Caitlin Cameron - 169 Newbury Street - Preliminary Traffic Comments

From: Tom Errico <thomas.errico@tylin.com>
To: Caitlin Cameron <CCameron@portlandmaine.gov>
Date: 2/12/2016 9:33 AM
Subject: 169 Newbury Street - Preliminary Traffic Comments
CC: David Margolis-Pineo <DMP@portlandmaine.gov>, Katherine Earley <KAS@port...

**2 DRIVEWAY APRON LAYOUT (I-9)**  
NOT TO SCALE

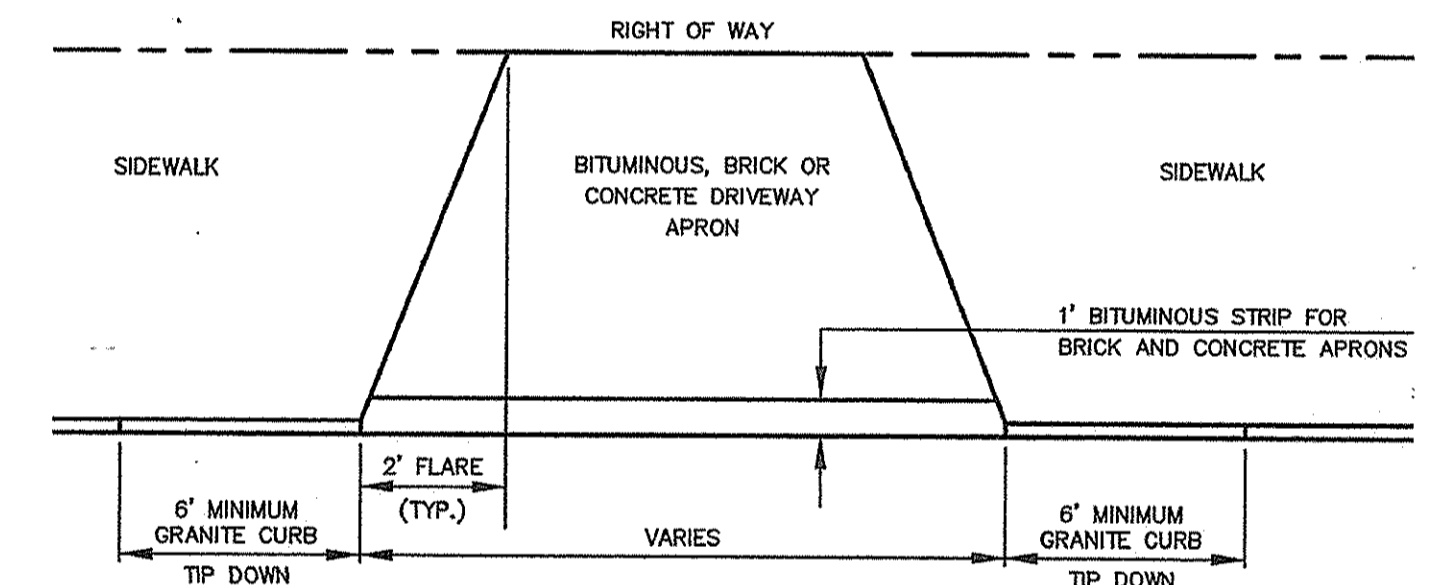
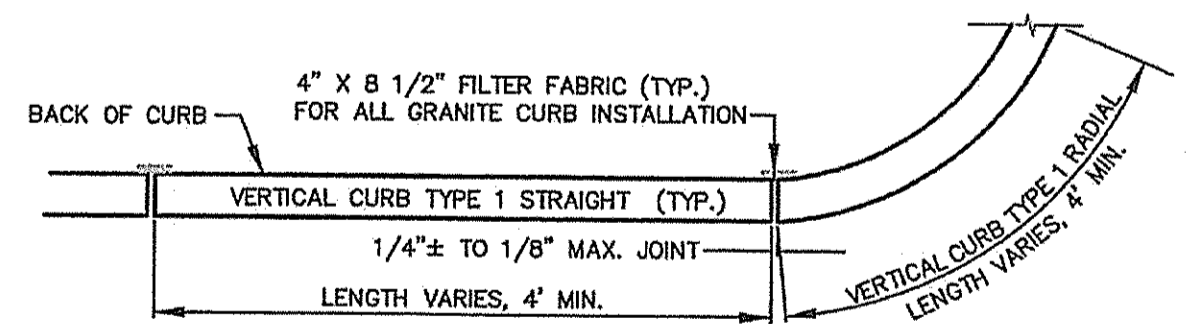
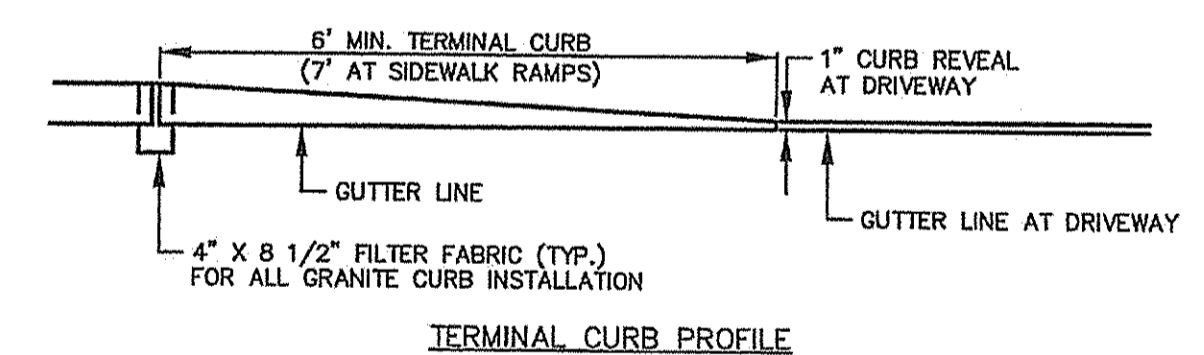
- Driveway width dimensions shall be noted. Additionally, sight distance from the garage driveways shall be noted (see comment below regarding Franklin Street connections).

- Turnaround requirements at both Newbury Street and Federal Street shall be coordinated with DPW.
- The applicant should illustrate how the proposed project and the 18-foot driving easement will accommodate existing vehicle parking requirements for the property for which the easement is located. Additionally, the driveway width at the Federal Street curb should be noted.
